Comment from Greenspace

APPLICATION NO: AL/51/19/PL

Site Address: Springfield and land to rear Hook Lane Aldingbourne PO20 3TE

Description of Works: Demolition of the existing dwelling & erection of 3 No 2-bed, 3 No 3-bed & 4 No 4-bed dwellings, access, landscaping & associated works.

Fig 7 - Proposed Site Layout Plan

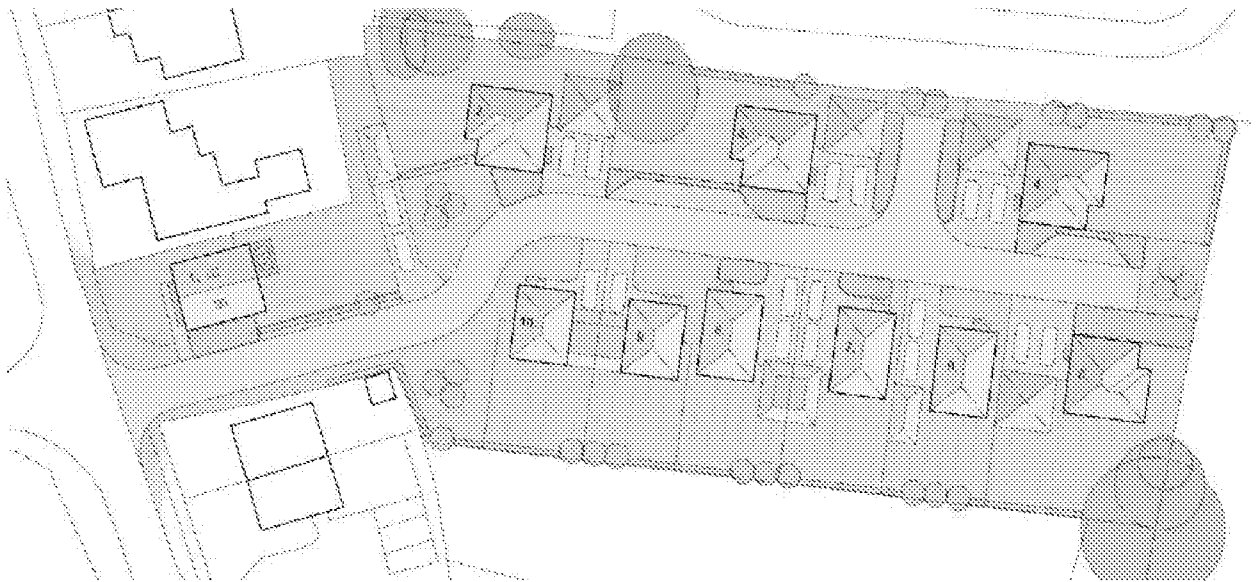
As this development does not exceed 10 dwellings then open space or play on site is not a consideration. However development of any kind should consider greening to add to the proposal and to enhance the setting. Indicative landscaping has been shown, for this development, further landscape detail should be provided forming a scheme that will maximise the biodiversity of the site with the inclusion of mixed ornamental and native species for the creation of a variety of habitats. The landscape proposals will need to be shown in plan form detailing species choice, planting densities and size at time of planting.

Any adjacent trees associated with this location and offsite that may have roots within the development area should be subject to tree protection measures. There may be conflict with existing trees to the north of this proposed development and also in relation to their longevity if the development were as laid out. Any tree removal/protection must be in agreement with Arun District Councils Tree Officer.
